Our Ref: 17068
Council Ref: SSDA 8517 & SSDA 8449

RE: SSDA 8517 and SSDA 8449 - Response to Request for Further Information

This letter has been prepared on behalf of Mirvac Projects Pty Ltd (Mircvac) to respond to the issues raised by the Department of Planning and Environment (Department) and other key stakeholders following their assessment of the Response to Submissions (RTS) reports submitted to the Department in support of SSDAs 8517 and 8449. A Response to each of the issues raised is set out below.

1.6 Travelator

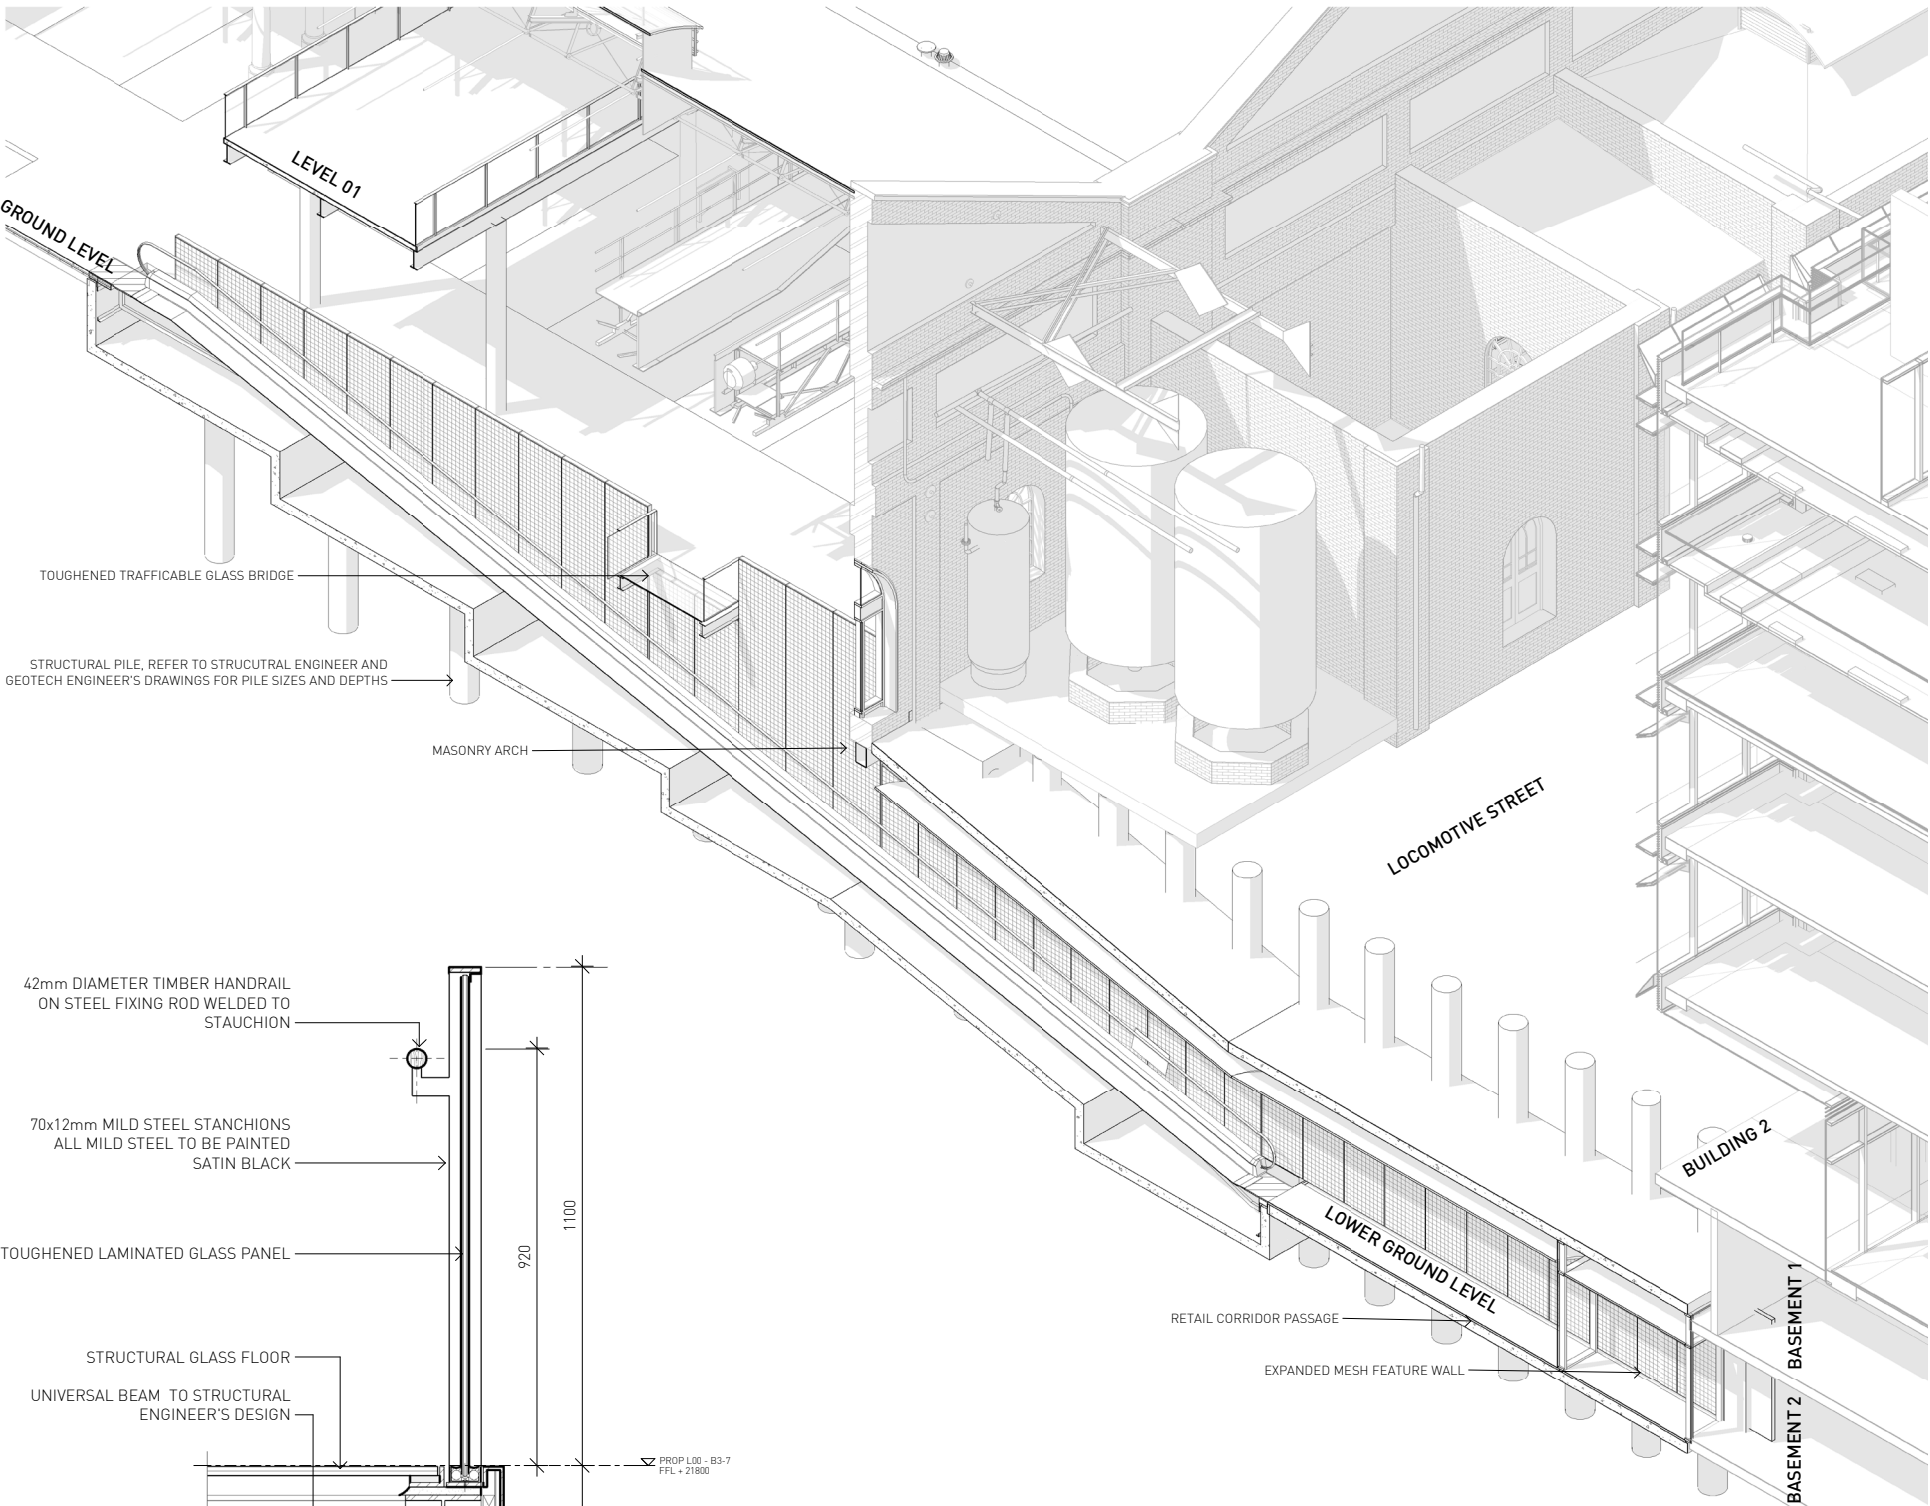
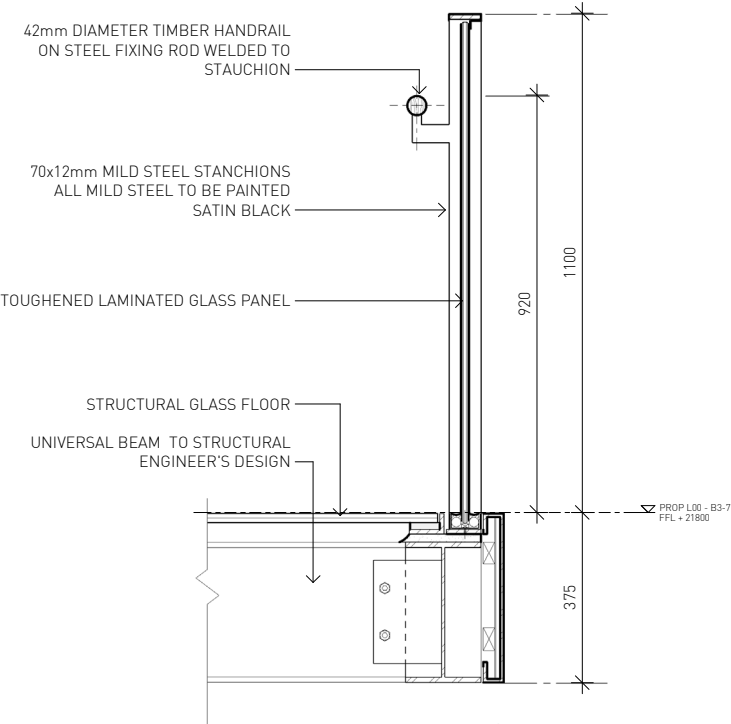
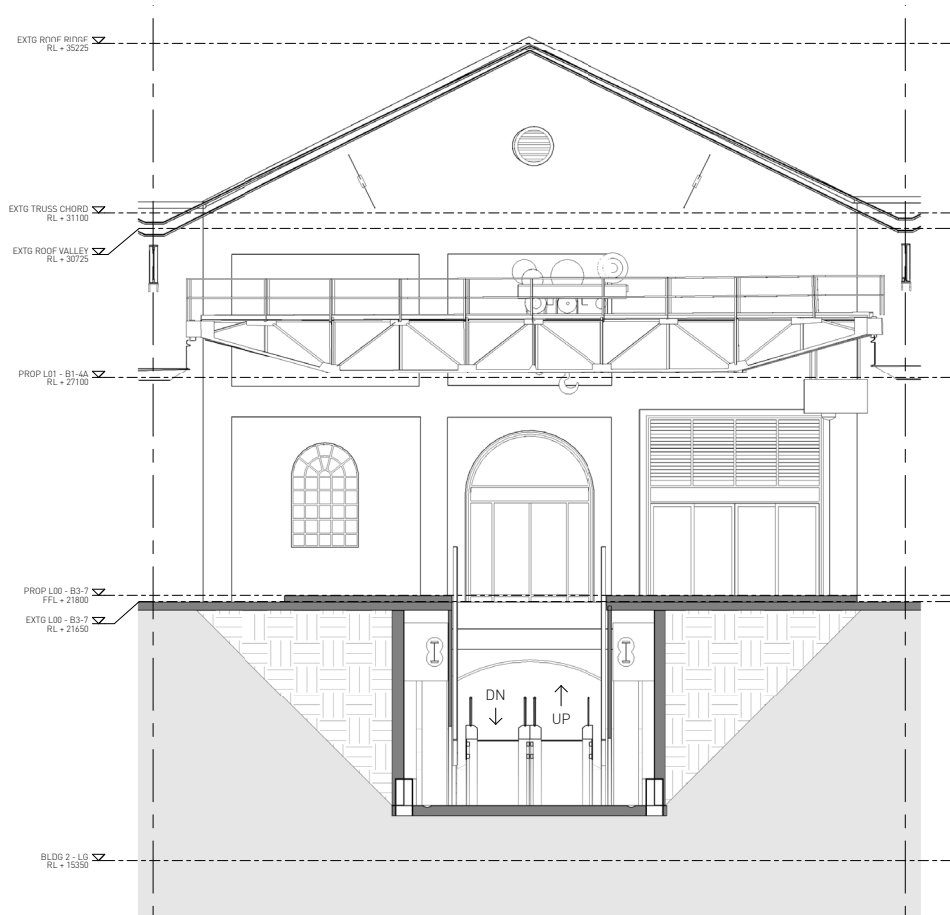
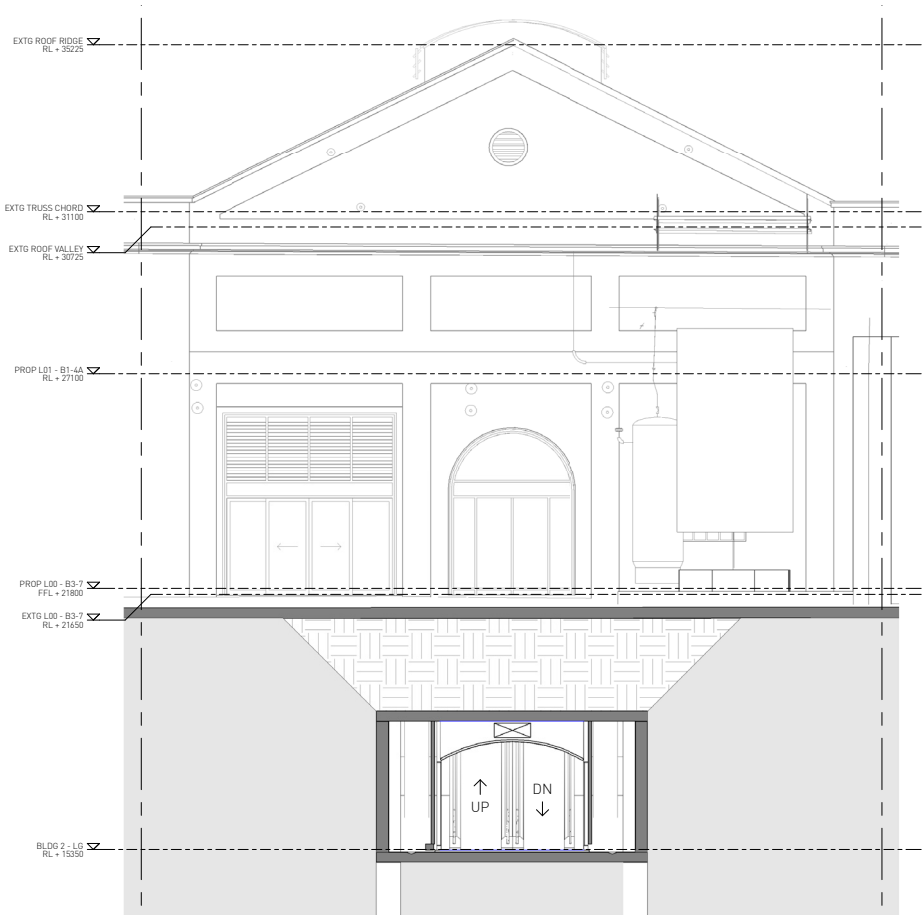
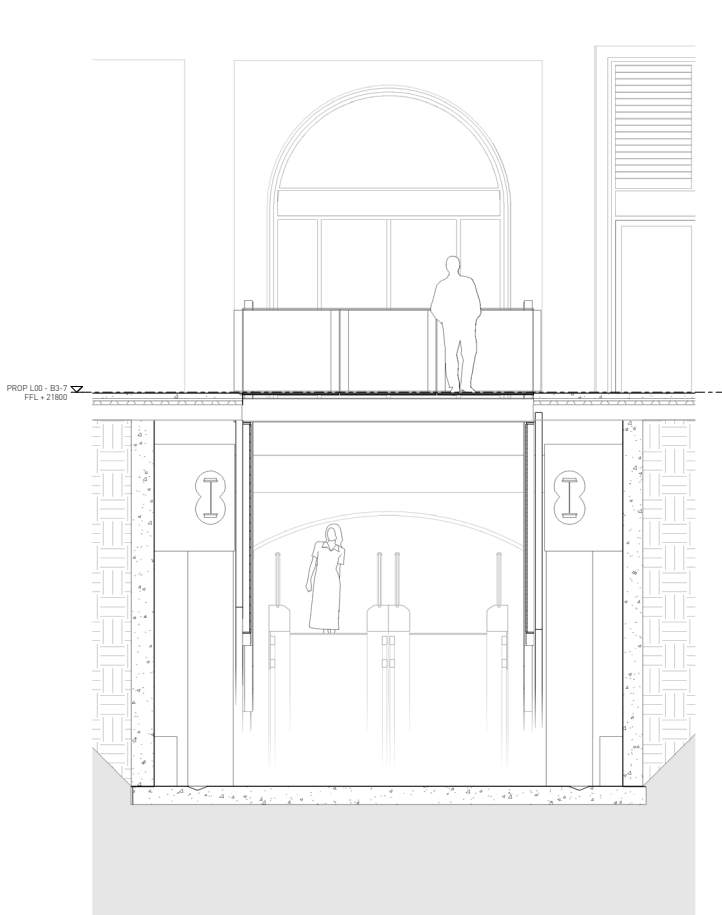
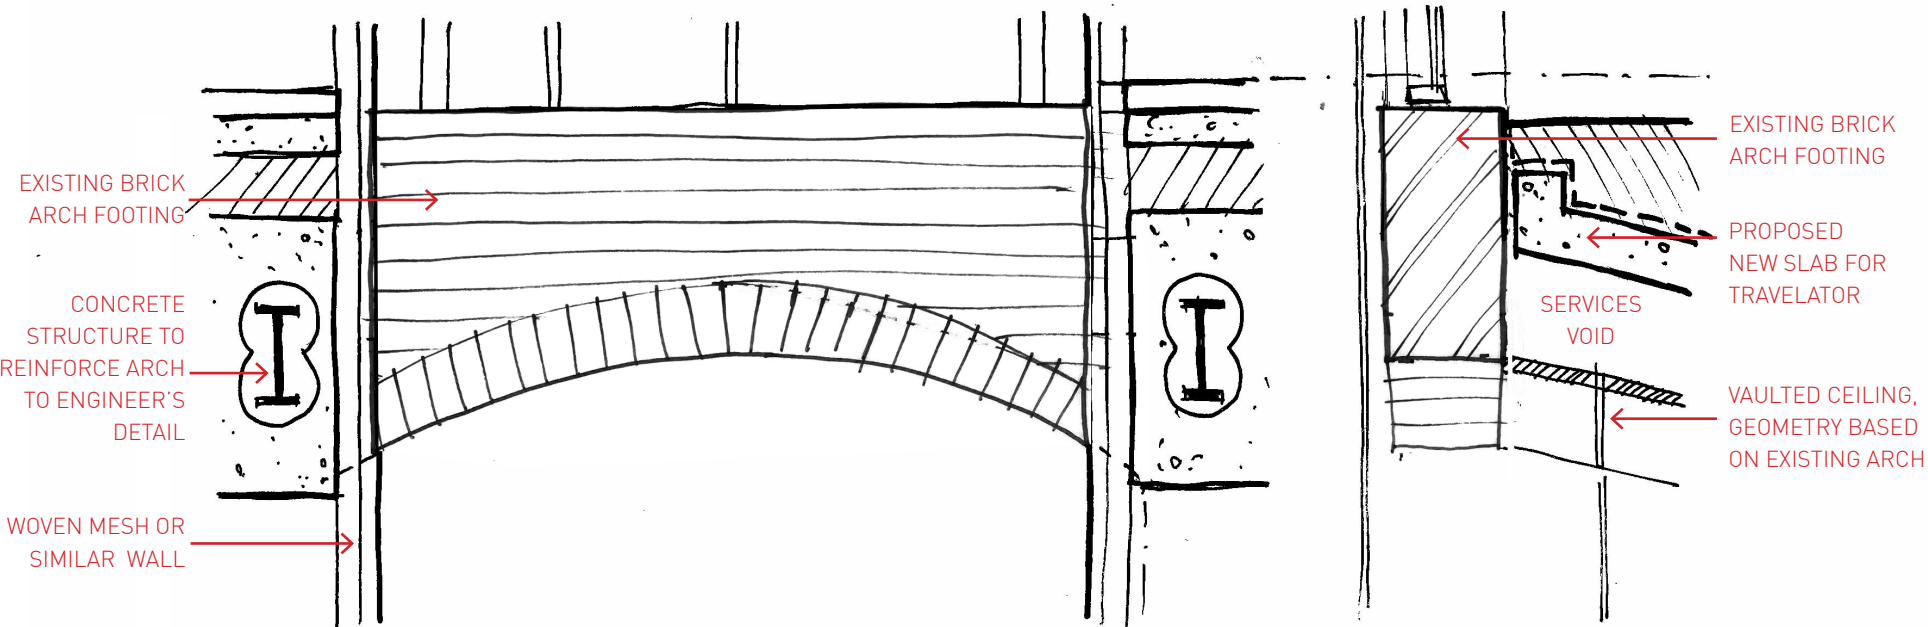
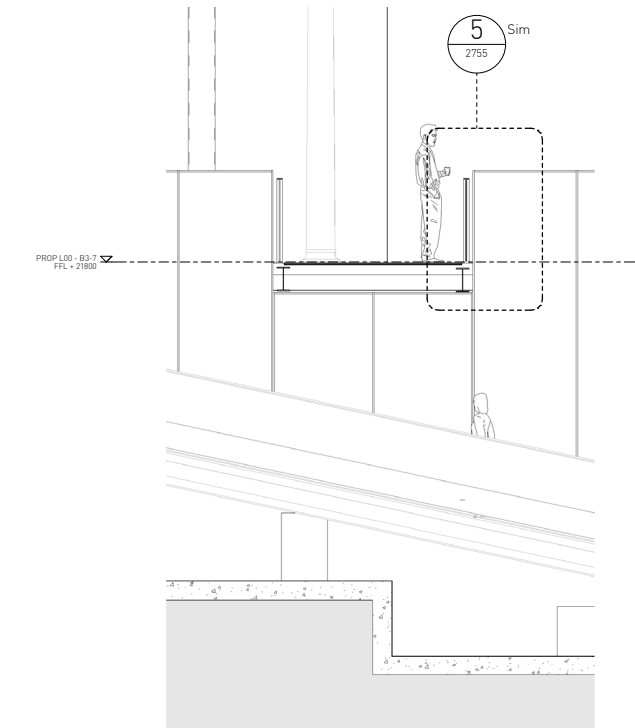
It is still unclear how the interpretation plan is informing the detailed design, in particular the detailed design of the proposed loading dock and travelator. We therefore recommend that the Stage 2 Heritage Interpretation Plan and detailed design for the Locomotive Workshop be submitted for approval prior to the issue of the first Construction Certificate. This is to ensure that the detailed design, in particular for the proposed loading dock and travelator, is informed by the interpretation plan and has regard for the overall interpretation of the site. This will enable a holistic assessment of the works. The plan must also take into consideration how lighting and signage will assist in the interpretation experience.

1.7 Signage

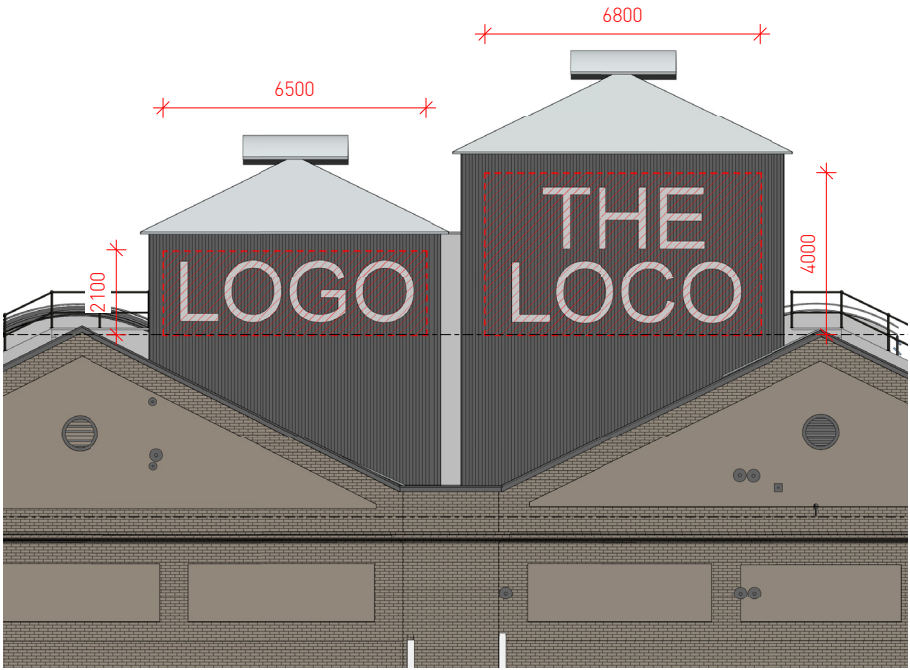
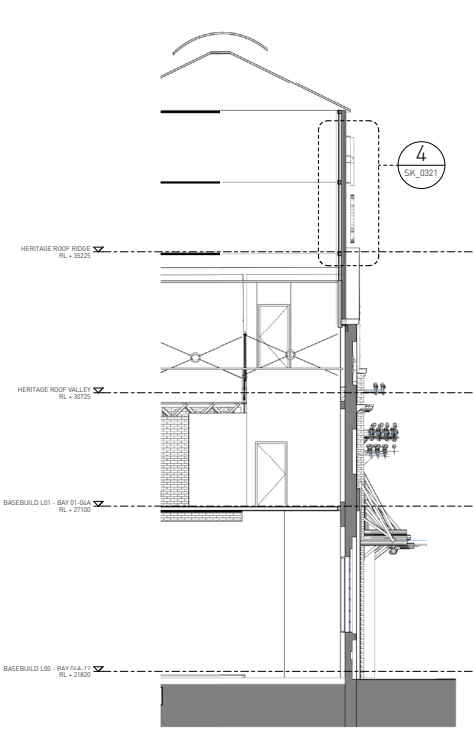
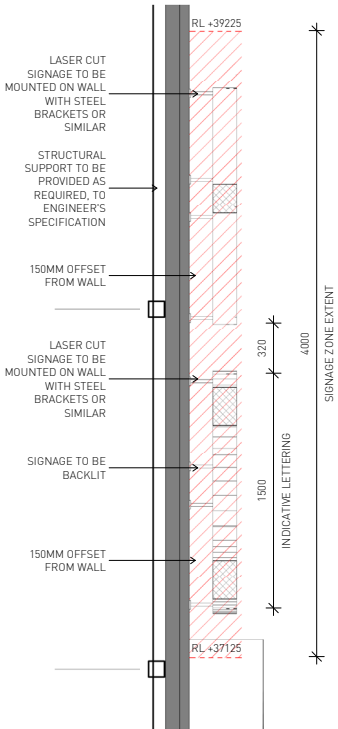
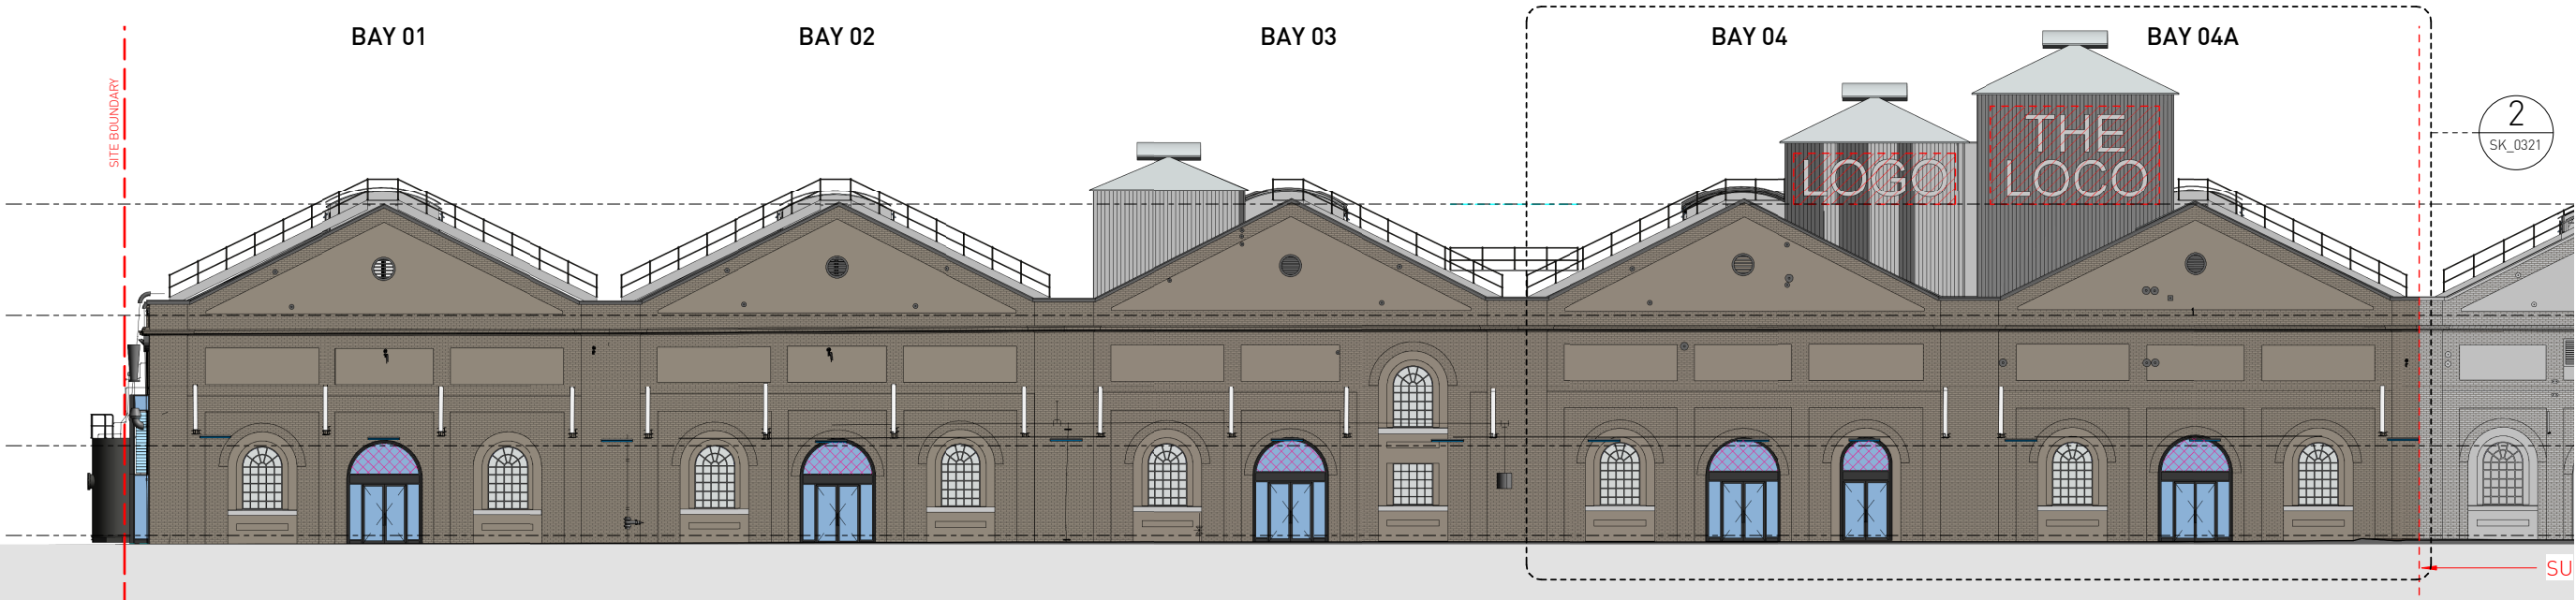
Address the response from the Heritage Council which identifies signage zones above the opening on the southern façade and the location of the proposed make up air louvres.

The signage zones for Bays 4 and 4a should relate to building identification/ precinct signs and not advertise an individual tenant or any third part advertising.

Development consent is only being sought for signage zones within SSDA 8517. The exact nature, form and type of signage will be subject to a separate development application which will (in all likelihood) be submitted to the City of Sydney for assessment and then will be assessed on its own merits.
